From: Vanessa Aziz
Sent: Monday, 13 May 2019 10:28 AM
To: 'Tim Green'
Subject: FW: Notification of Exhibition of upgrades to Australasian Steam Navigation Company Building (SSD 8967) - The Rocks.
Attachments: SSD 8967 - Notice of Exhibition - Approved Letters_Council.pdf; SSD 8967 - Exhibition - Advertisement.pdf

The application seeks approval for the installation of an external access ramp, removal of obsolete theatrettes in Bay 5 (associated with an entertainment venture known as The Story of Sydney); works to Bays 4 and 5 including upgrade of amenities and services, and replacement of lifts; reinstatement of heritage timber floors in Bay 5; new flue and the fire upgrade for the whole building .

MMD-389718-S-DR-00-XX-0070

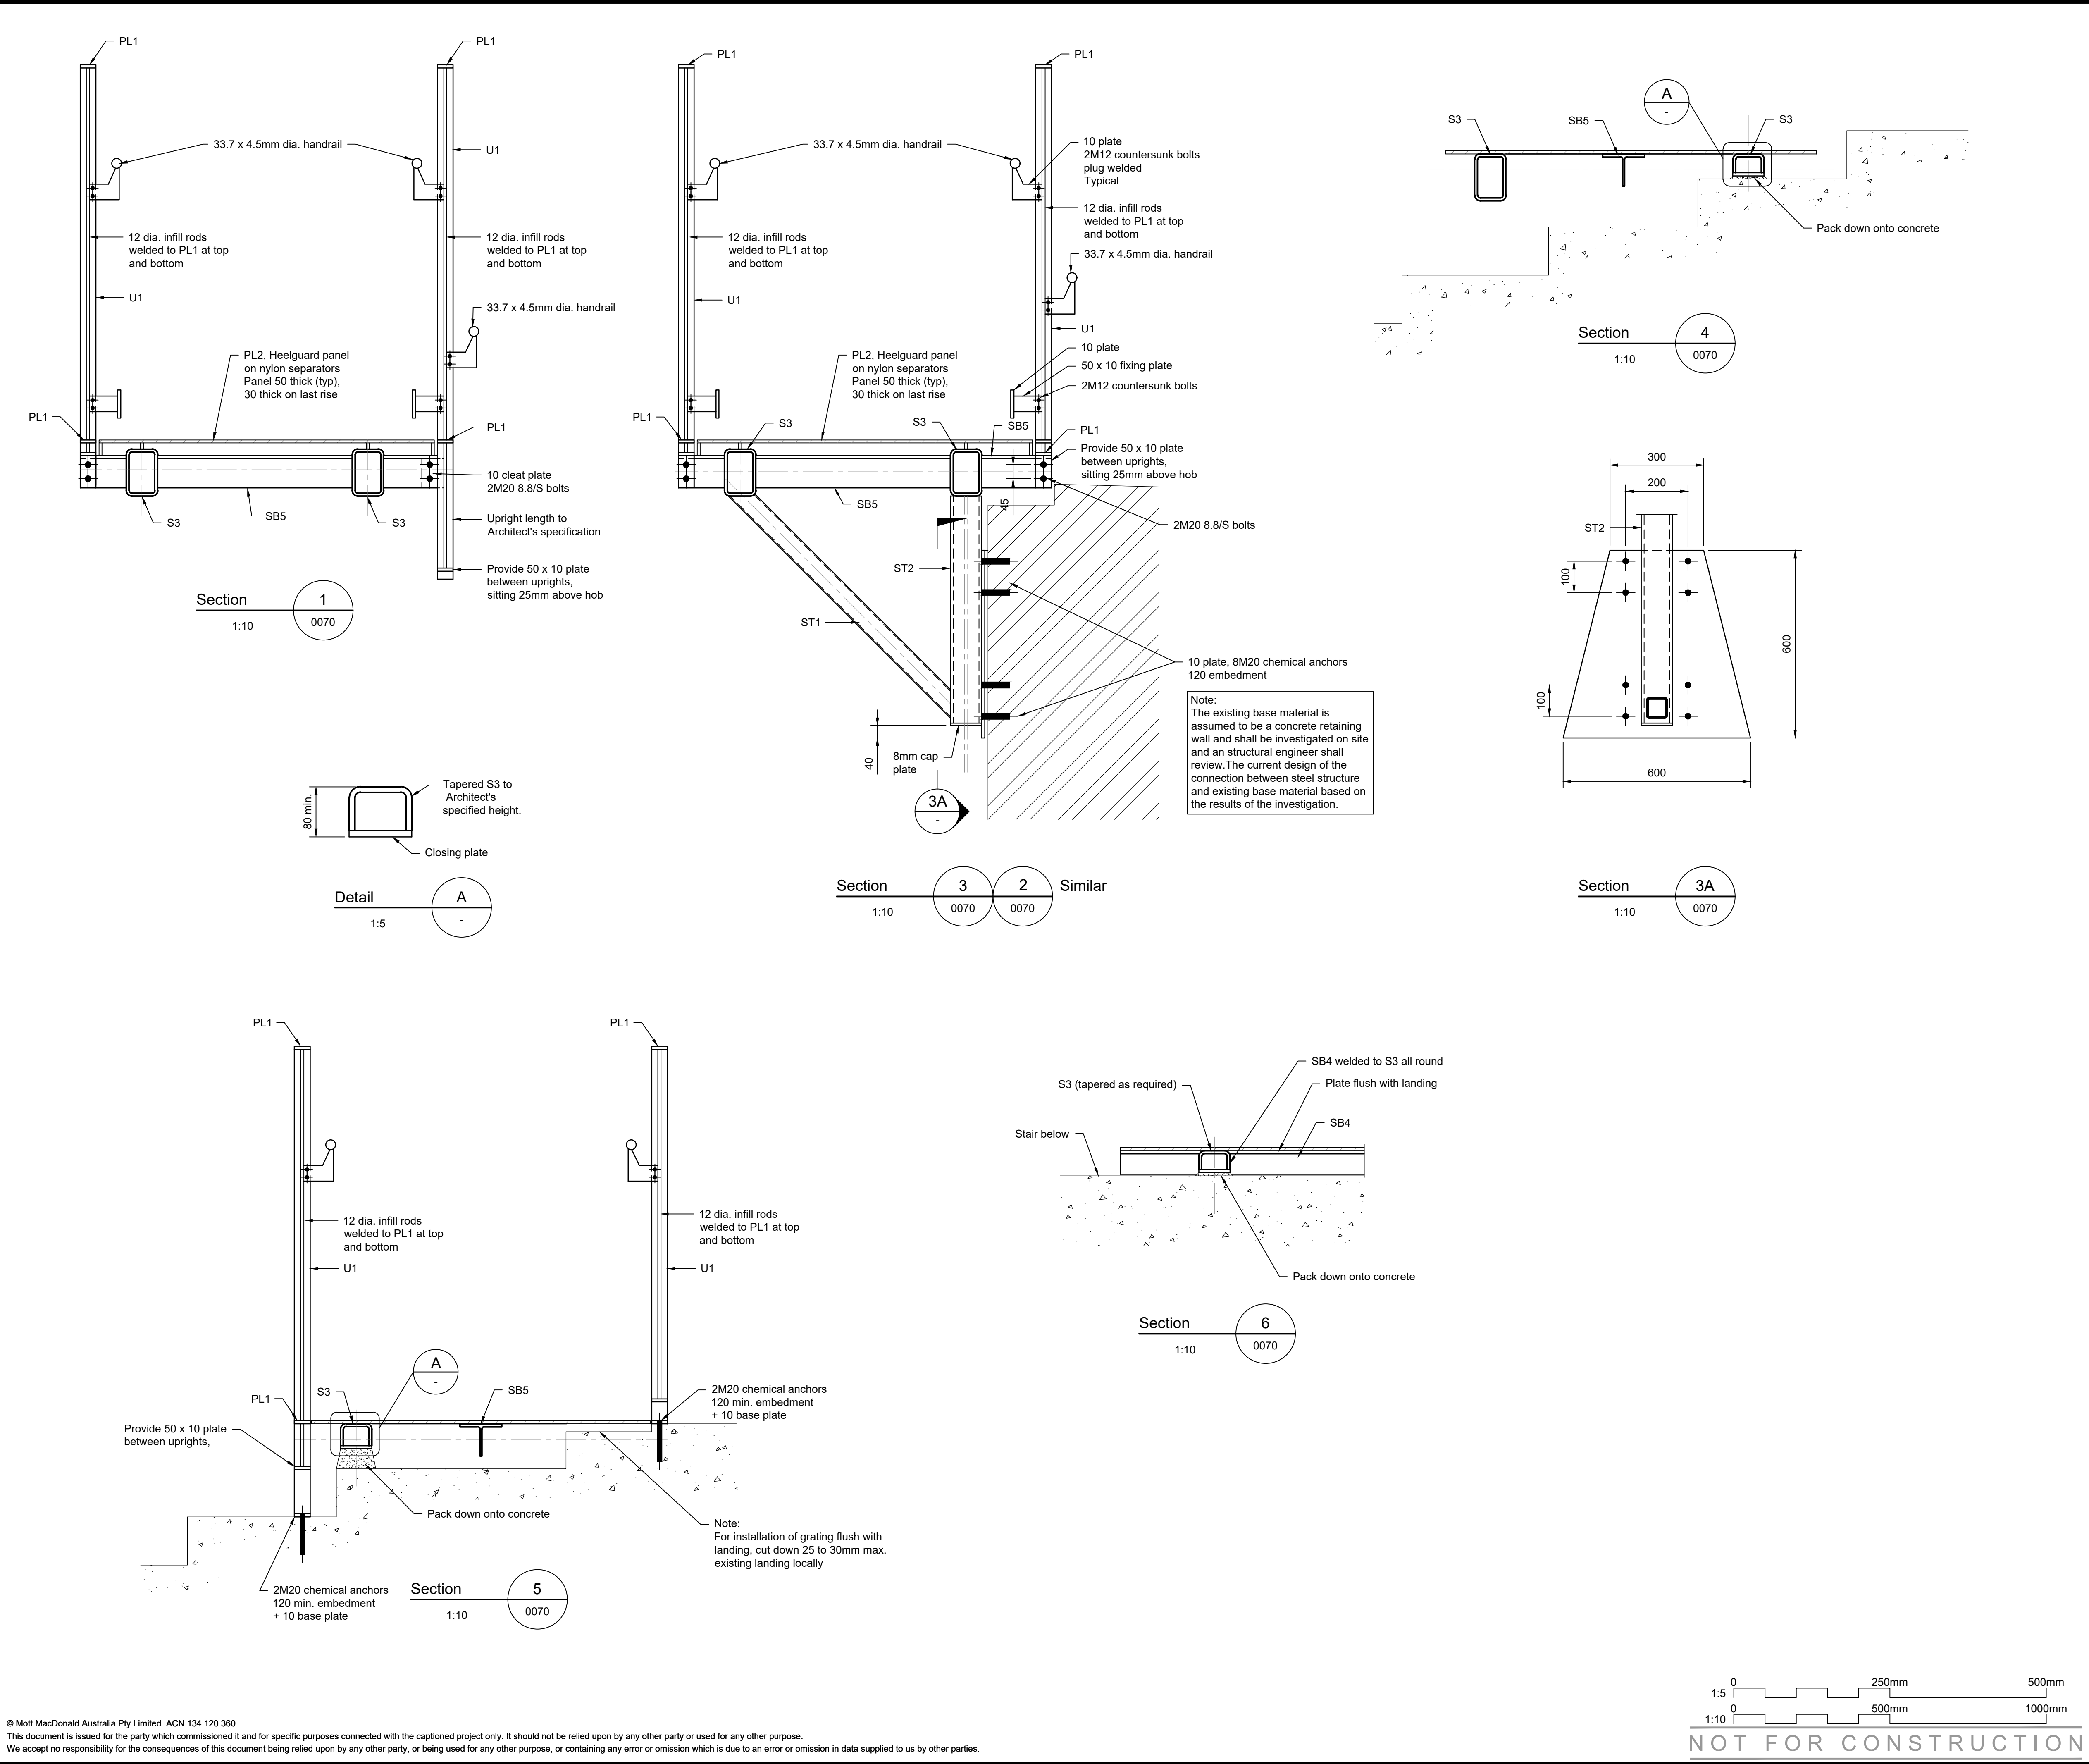
- The proposed external ramp will have some impact on the building. It is required to provide disable access into the building and its design has been carefully considered so as to not touch or be fixed to the building. The detailing of the ramp balustrade similar to that of the existing balustrades enclosing the light courts is supported in principle. The doors within the opening for the ramp are to be removed and stored within the building.

- Encroachment - private property elements must not encroach into the public domain. This includes things like ramps, steps, handrails and Tactile Ground Surface Indicators (TGSIs). Property boundaries and extent of works lines must be clearly shown on the plans.
